Application by Steeple Solar Farm Limited for an order granting development consent for the Steeple Renewables Project

The Examining Authority's written questions and requests for information (ExQ1)

Issued on 11 December 2025

Figure 7.13.1: Skylark mitigation in the Western Biodiversity Mitigation Area

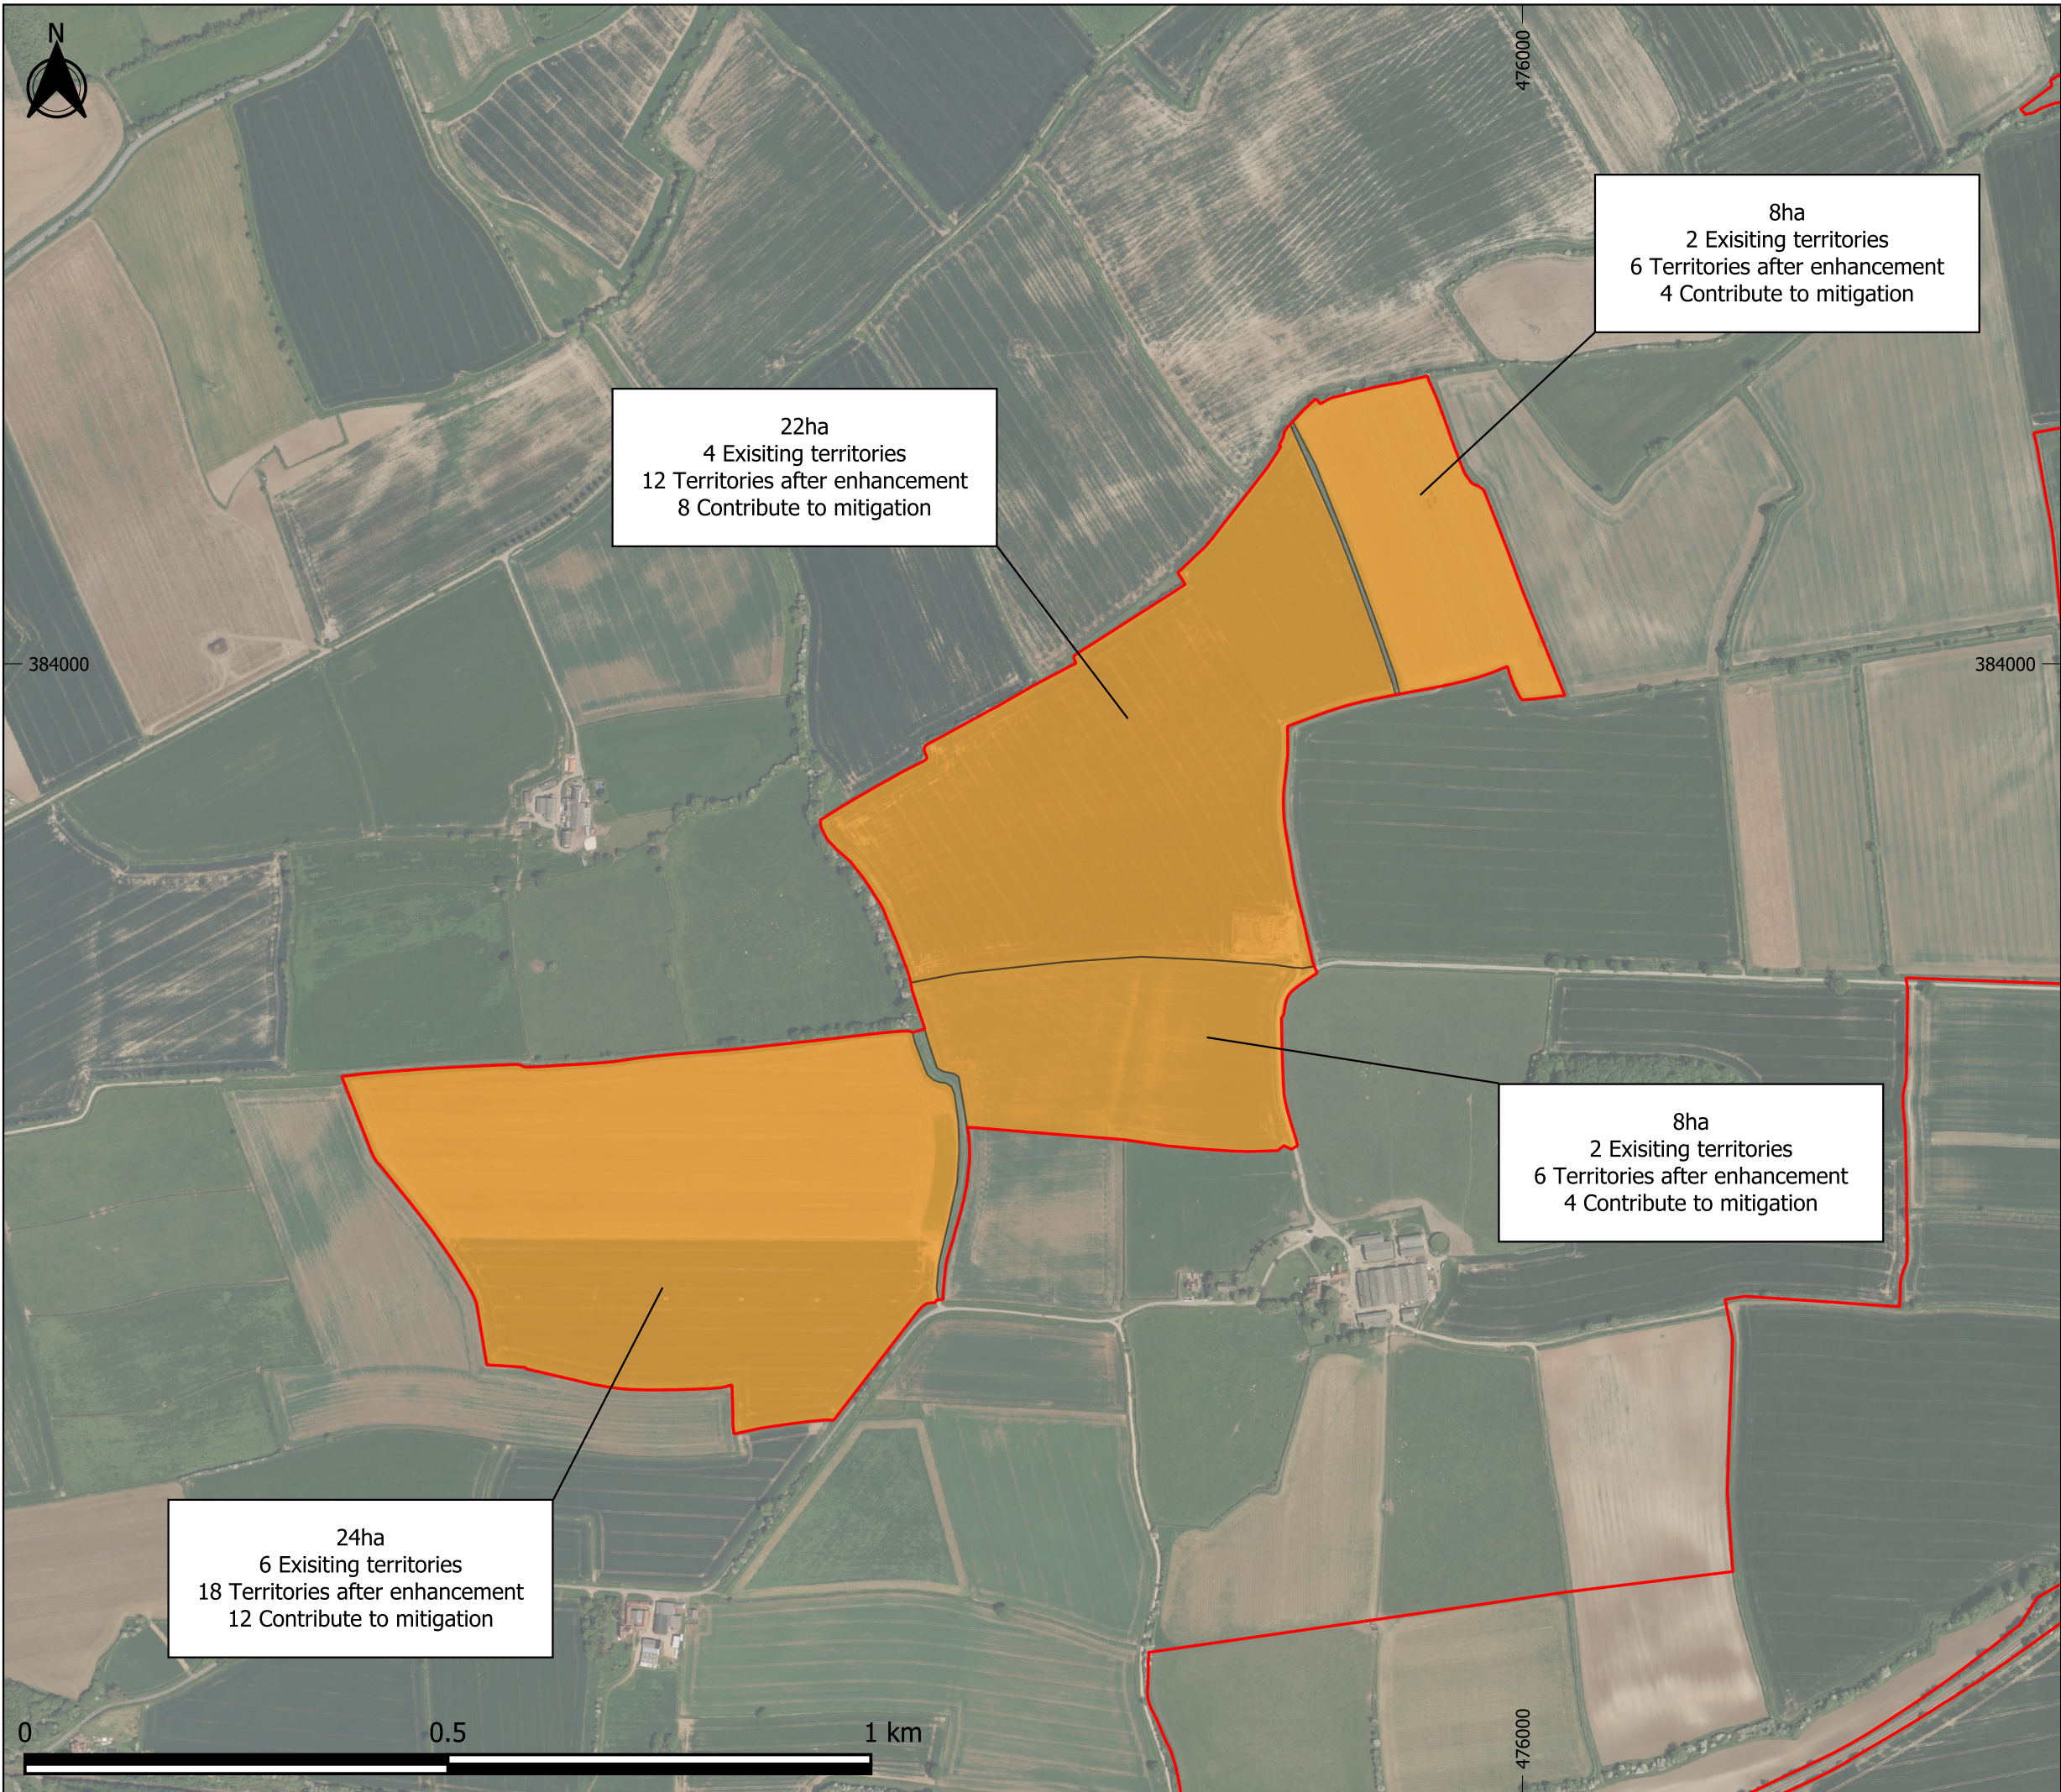
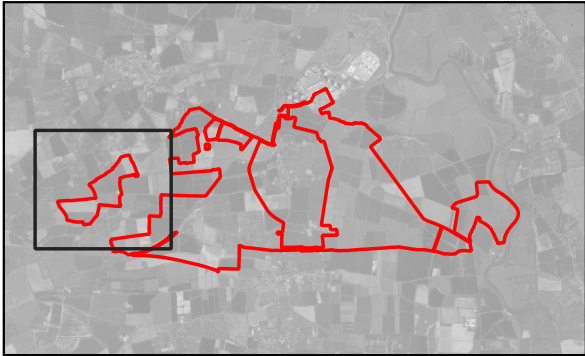
ExQ1	Question to:	Question:
Q5.0.3	The applicant	<p>Skylark Mitigation Strategy</p> <p>The mitigation strategy [APP-125] sets out measures in the form of identifying arable fields that are considered suitable to support nesting territories of skylark. Explain:</p> <ol style="list-style-type: none"> 1. Why a higher figure of mitigation than the approximate 55% to 64% of the territories likely to be displaced has not been proposed and the consideration that was given to increase this percentage. 2. How other areas, as referred to in paragraph 4.5, are intended to be factored in later in the process and when this would be. Would such areas result in an improvement to the 55% to 64% mitigation? If so, should it be secured in the dDCO?
Q5.0.4	The applicant	<p>Ecology and Fisheries</p> <p>The EA [RR-025] and [REP1-016] has raised concerns regarding the lack of aquatic habitats and species in the Outline Decommissioning Plan [APP-090]. In response [REP1-008], you have stated that the Outline Decommissioning Plan can be updated as part of the examination process.</p> <p>Provide further clarity on whether you intend to update the Outline Decommissioning Plan to address the EA's concerns and if so, when. If not, confirm whether your comments that there are "currently no proposals to undertake any work in waterways or aquatic habitats as part of the decommissioning phase" means that you do not consider it necessary to update the Outline Decommissioning Plan.</p>
